# CITY OF ALBUQUERQUE

Site: MJ Hospitality, LLC., Self Storage, 1400 Yale Blvd NE

**Re: Drainage Ordinance (14-5-2-11) Violations for Erosion and Sediment Control**

Drawing file: ESC / 24x36 Stamped ESC Map.pdf

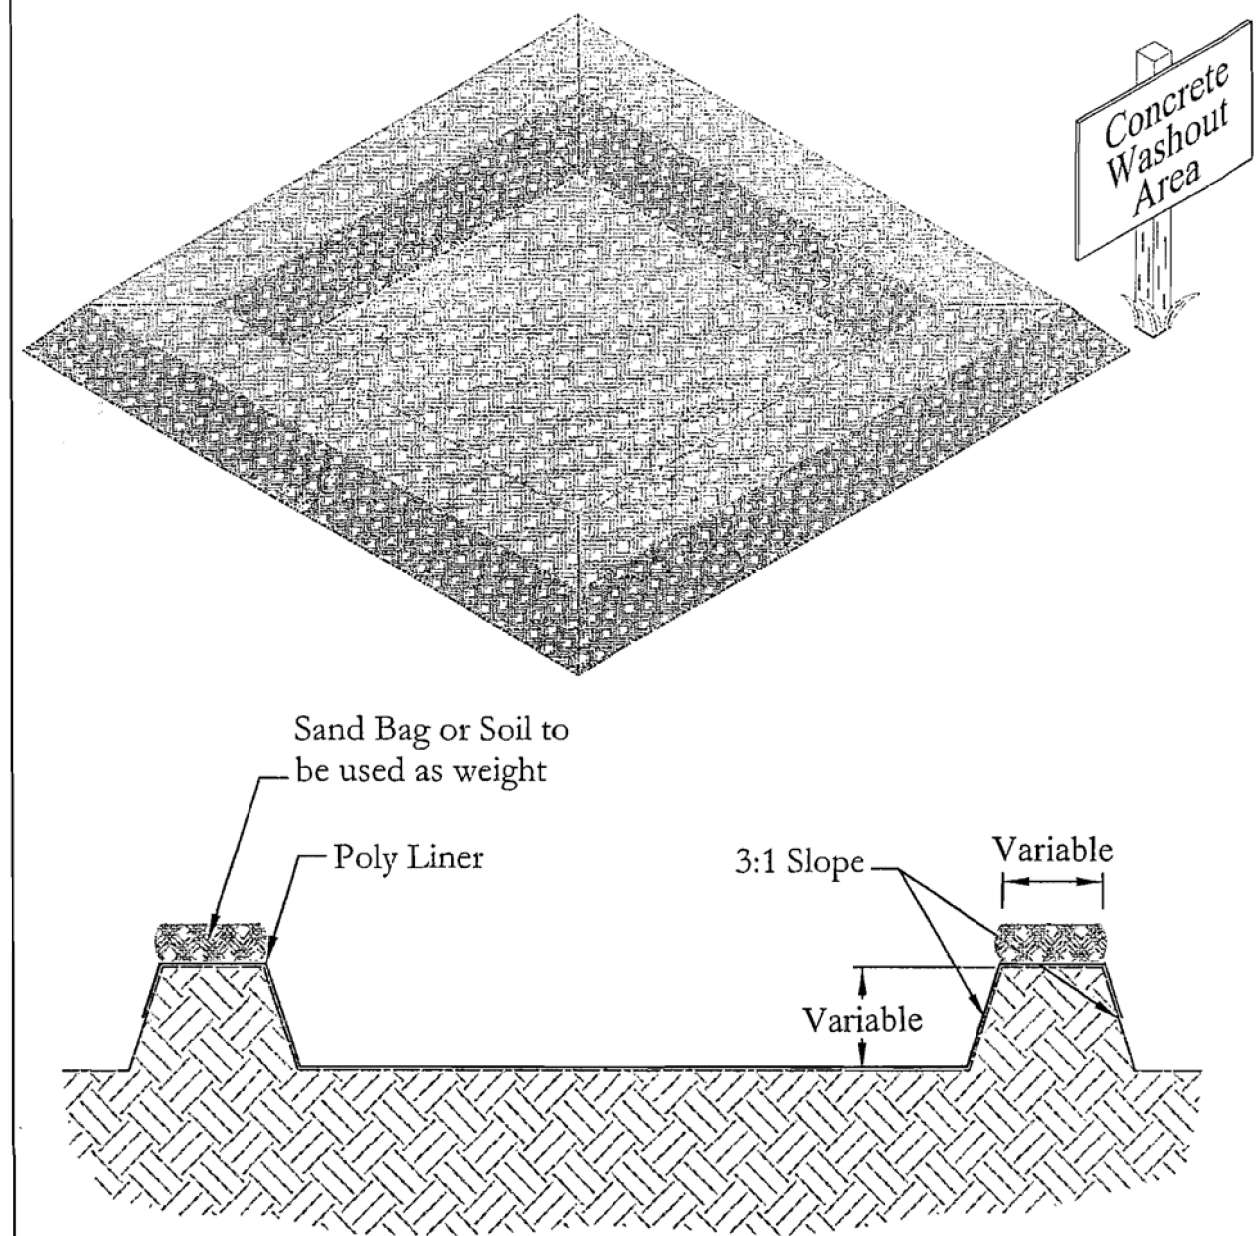
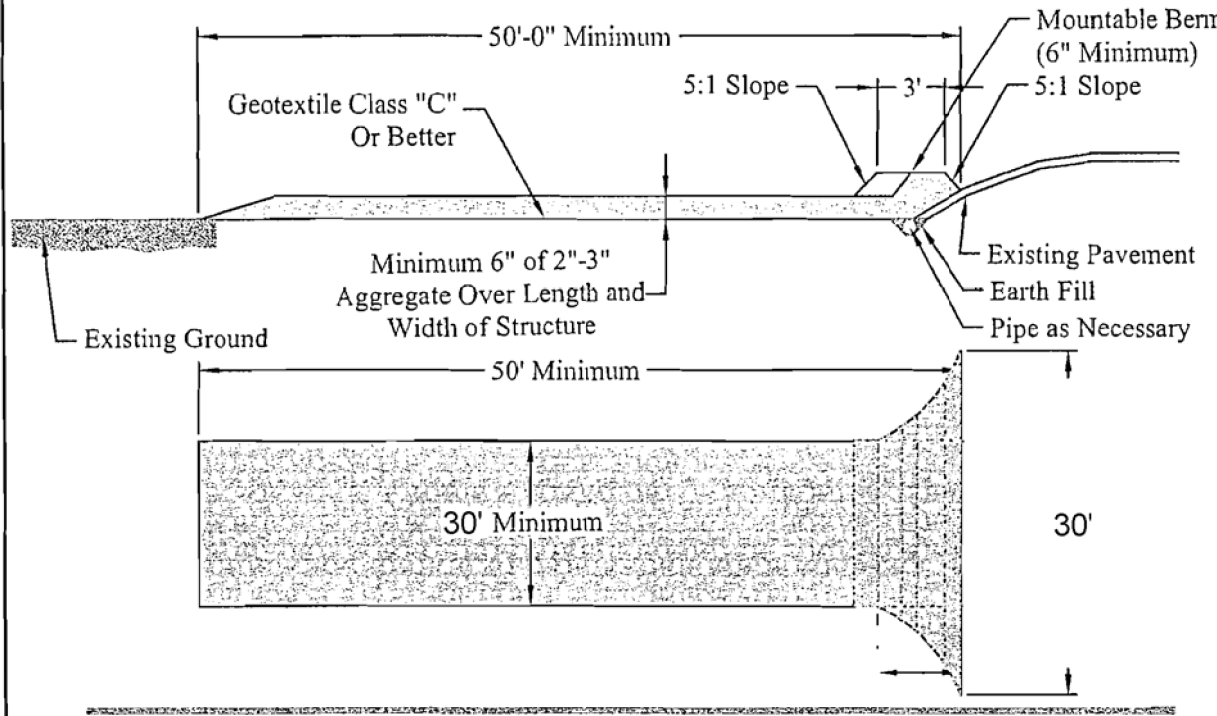
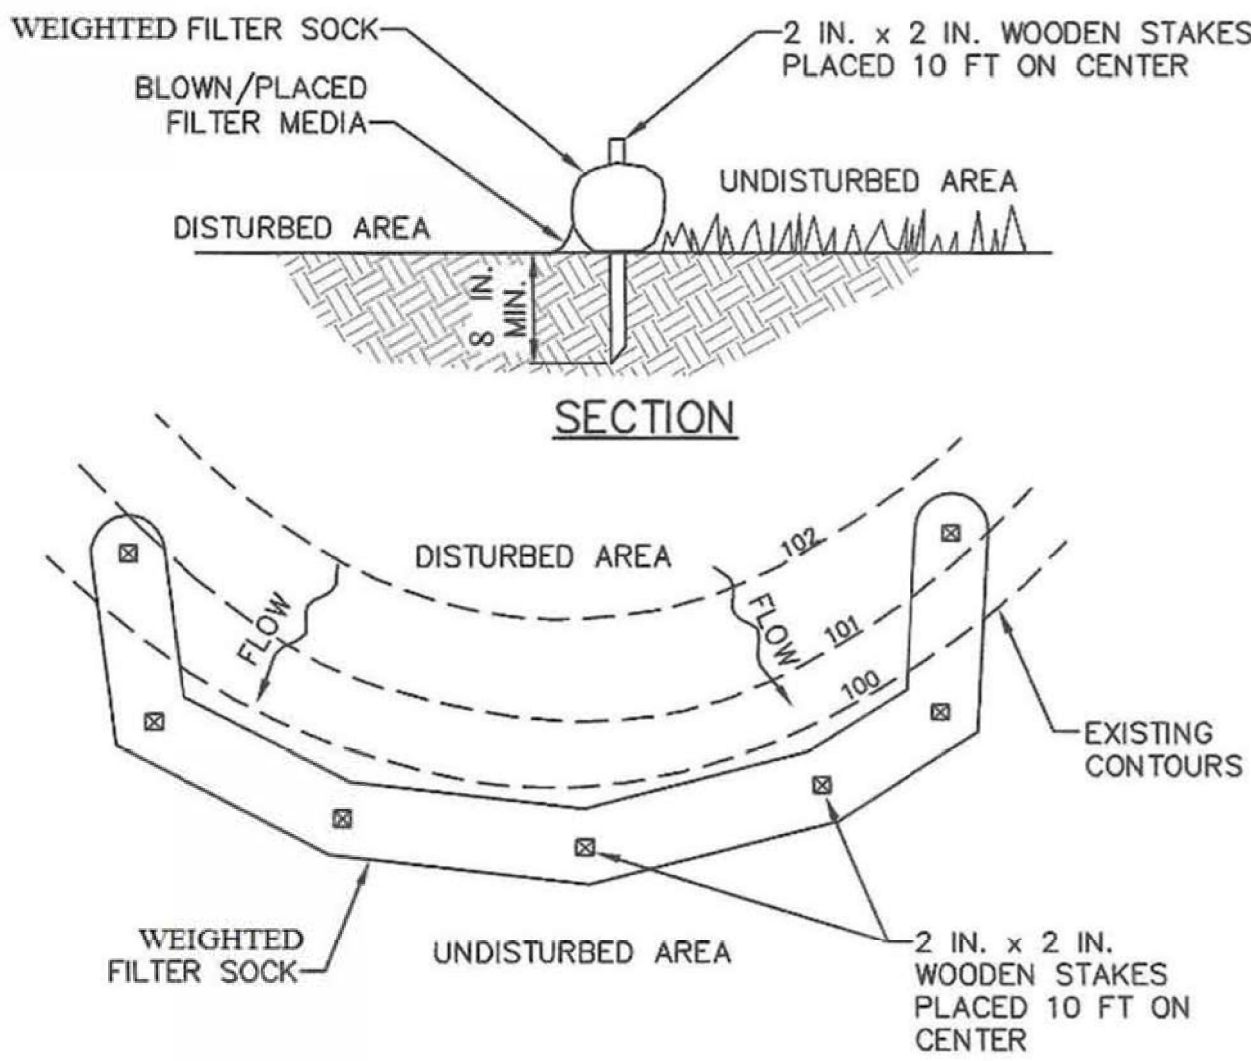
1. The construction activities on this site have encroached into the adjacent properties owned by the City of Albuquerque on the north and south and the United States on the east. Google earth photos show that these offsite areas had vegetation before this project started. These offsite areas have been inactive for more than 14 days and erosion controls were removed before the Final Stabilization criteria was satisfied.

1. Stabilize all bare areas within 21 days per CGP 2.2.14, and maintain BMPs and self-inspections until the Final Stabilization Criteria, CGP 2.2.14.b, is satisfied. Provide specifications for the stabilization measures to adjacent owners for their approval prior to construction and obtain permits to work on public property from both government authorities. Keep records of the materials, quantities and rates and dates of application with the SWPPP and provide copies to both public agencies when ready for their final inspection.
